### **East Anglia One North (EA1N) and East Anglia Two (EA2) Offshore Wind Farms**

**Planning Inspectorate Reference: EA1N – EN010077 &  
EA2 – EN010078**

**East Suffolk Council's Response to Additional  
Information Submitted by the Applicants at Deadline**

## **Review of Additional Information Submitted by the Applicants at Deadline 8**

Figure: 29.17e
Viewpoint 5: Public Right of Way, near Moor Farm

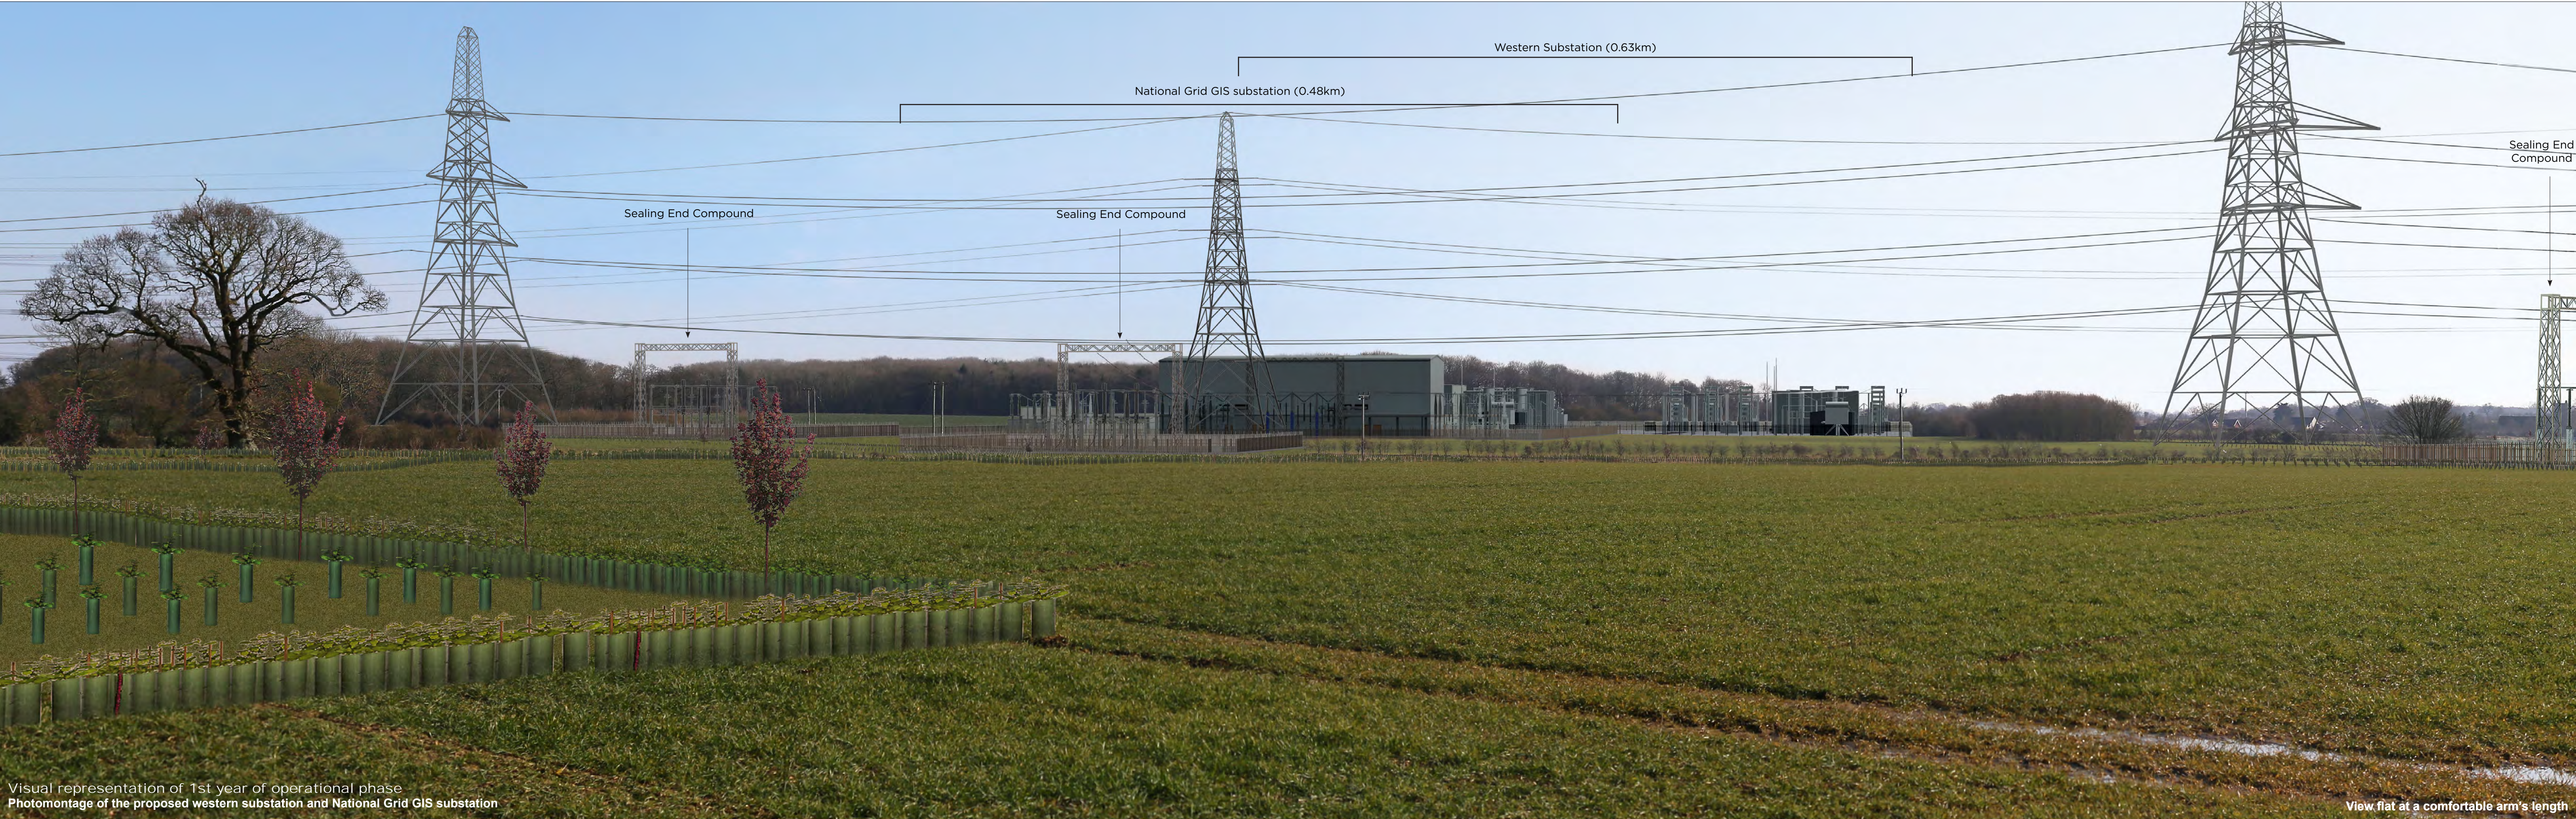
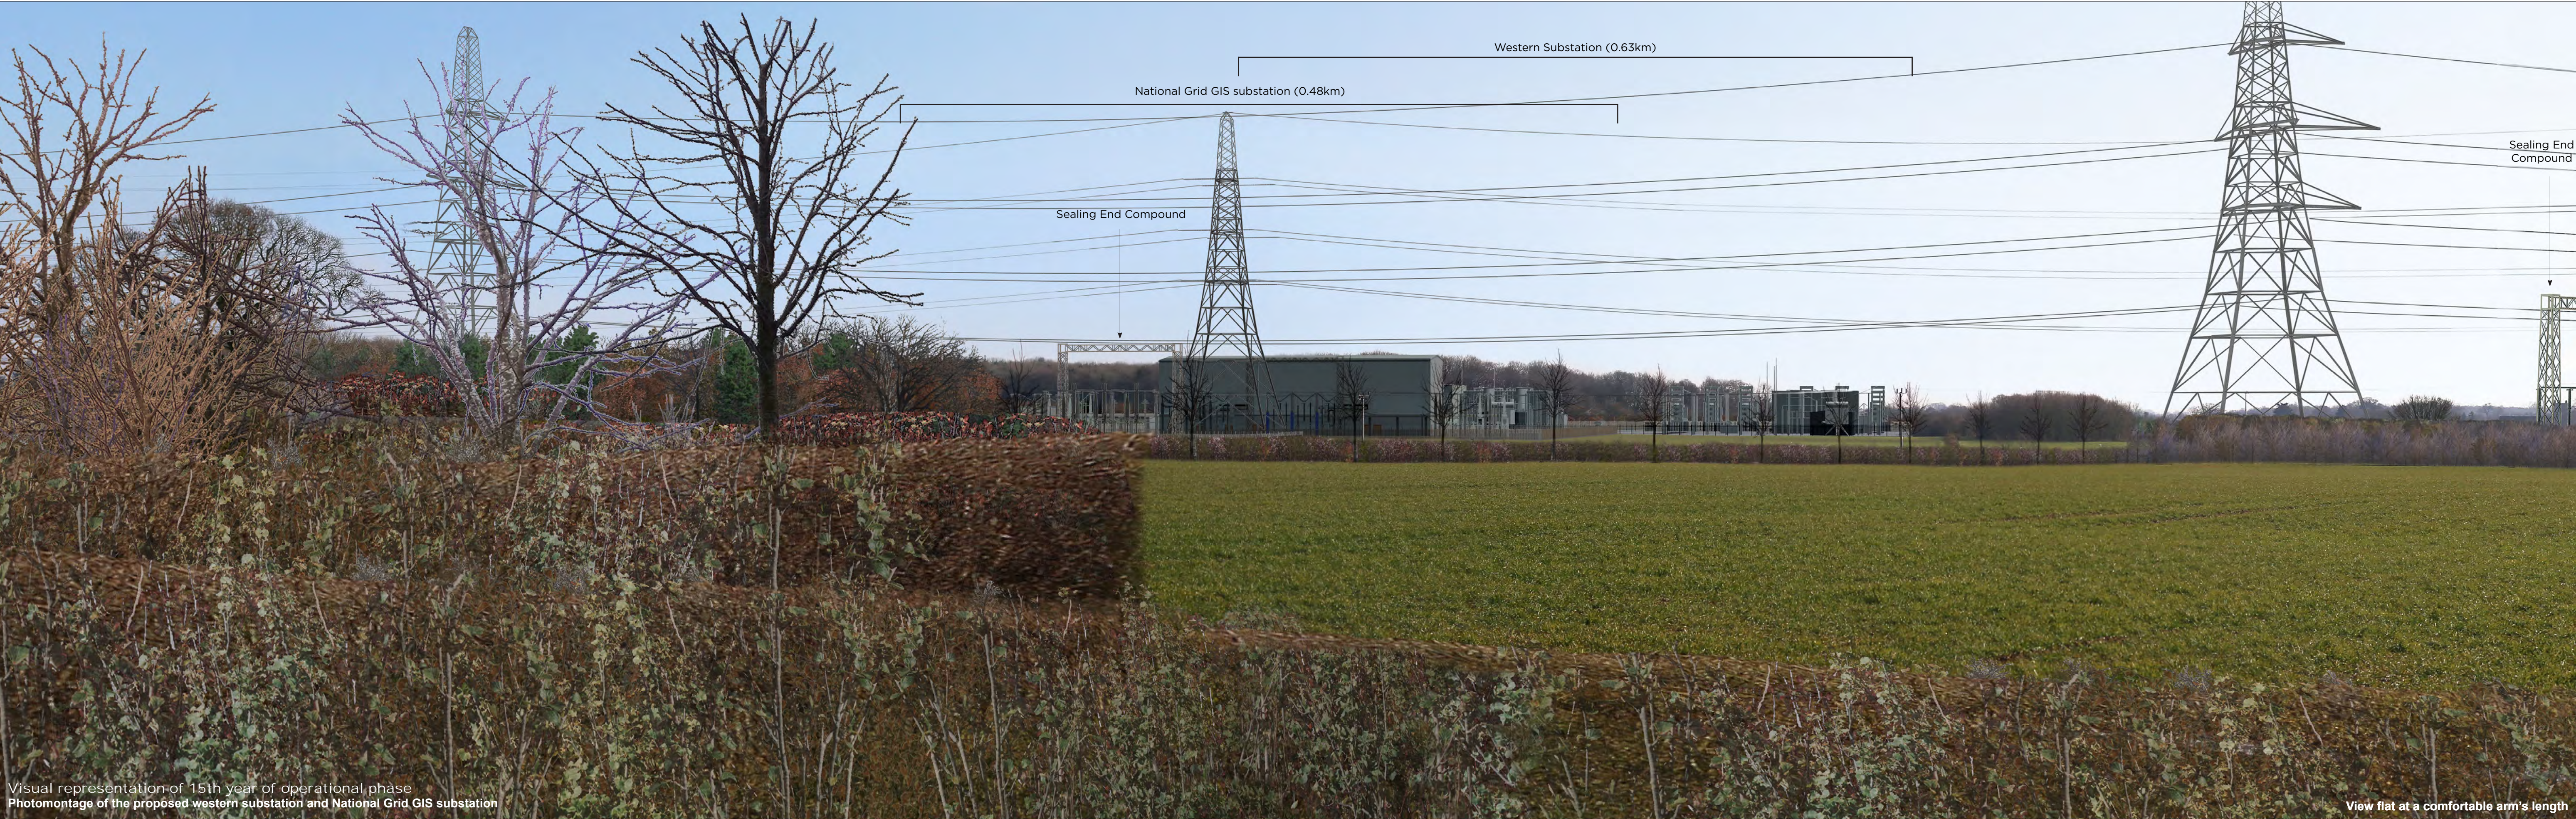
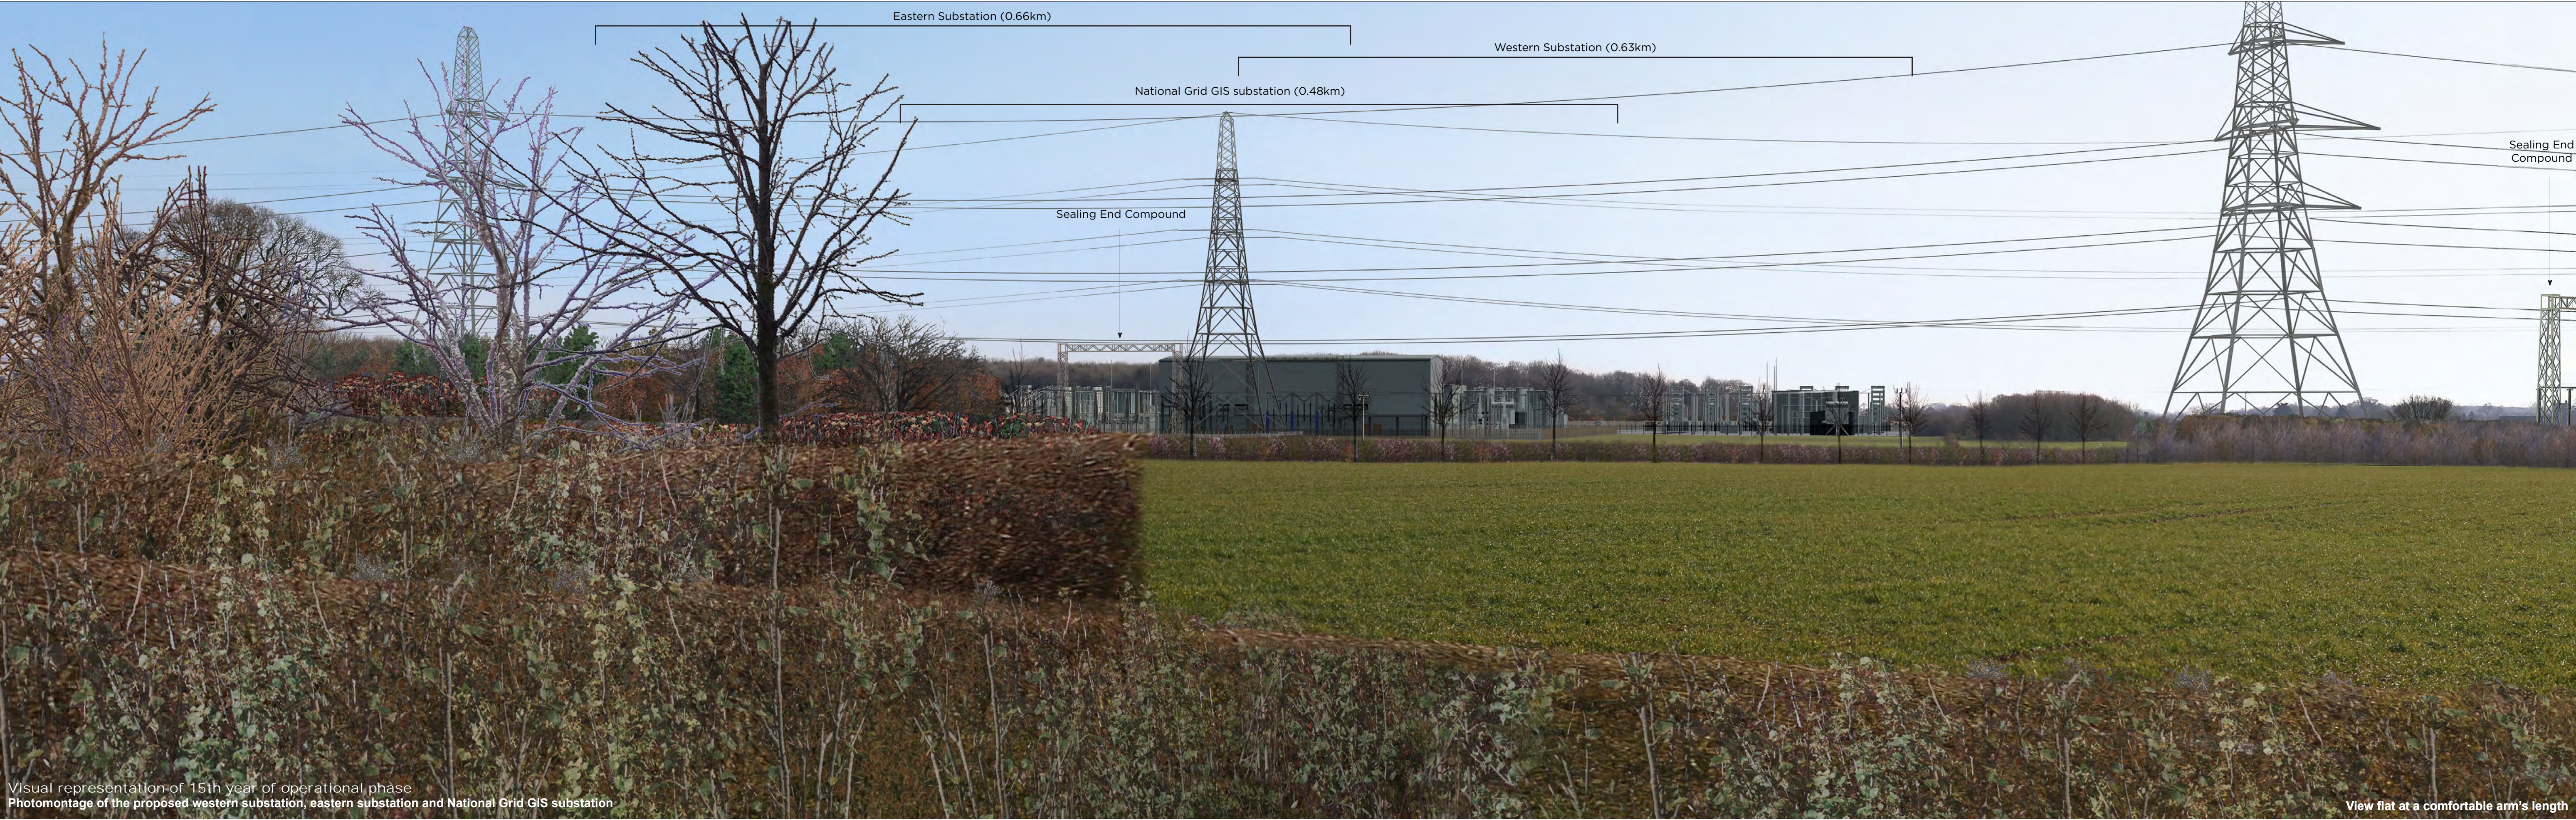
<p><b>Cultural Heritage Viewpoint 5 Additional Visualisations – REP8-063</b></p>		
		<p>ESC noted in previous responses that the usefulness of CHVP5 is limited due to the specific location the viewpoint was chosen from (REP4-059). These additional visualisations are therefore welcomed, as they give a better idea of how the setting of Woodside Farm would be impacted. The visualisations confirm previous assumptions, that the top of the substations would still be visible above the treeline at 15 years, and that the large scale of the substations would still be notable. ESC maintains its position that the magnitude of adverse impact would be medium, giving rise to an effect of moderate significance (page 31/32, REP5-048).</p>
<p><b>National Grid GIS Substation Photomontages</b></p>		
		<p>The provision of updated photomontages showing the Gas Insulated Switchgear (GIS) Substation option are welcome. The overall footprint of the National Grid substation is</p>

<p>significantly smaller although the building structures associated with this technology would be taller and have a larger solid mass than the Air Insulated Switchgear (AIS) substation option.</p> <p>The Environmental Statements are based on the use of an AIS National Grid substation, and although the photomontages are useful, no equivalent assessment to that within the Environmental Statements has been provided in relation to a GIS National Grid substation. Without a full assessment of the GIS option, it is not possible for ESC to fully compare the impacts of the two technologies and assess the degree to which one technology is beneficial over the other. The lack of a full assessment of the GIS option also limits the Examining Authority’s ability to recommend to the Secretary of State that one technology should be favoured over another and prevents the ability for only the GIS option to be consented by the DCOs.</p> <p>Based on the information available, the comments contained within paragraphs 14.13 to 14.14 of the Local Impact Report (REP1-132) remain relevant.</p>
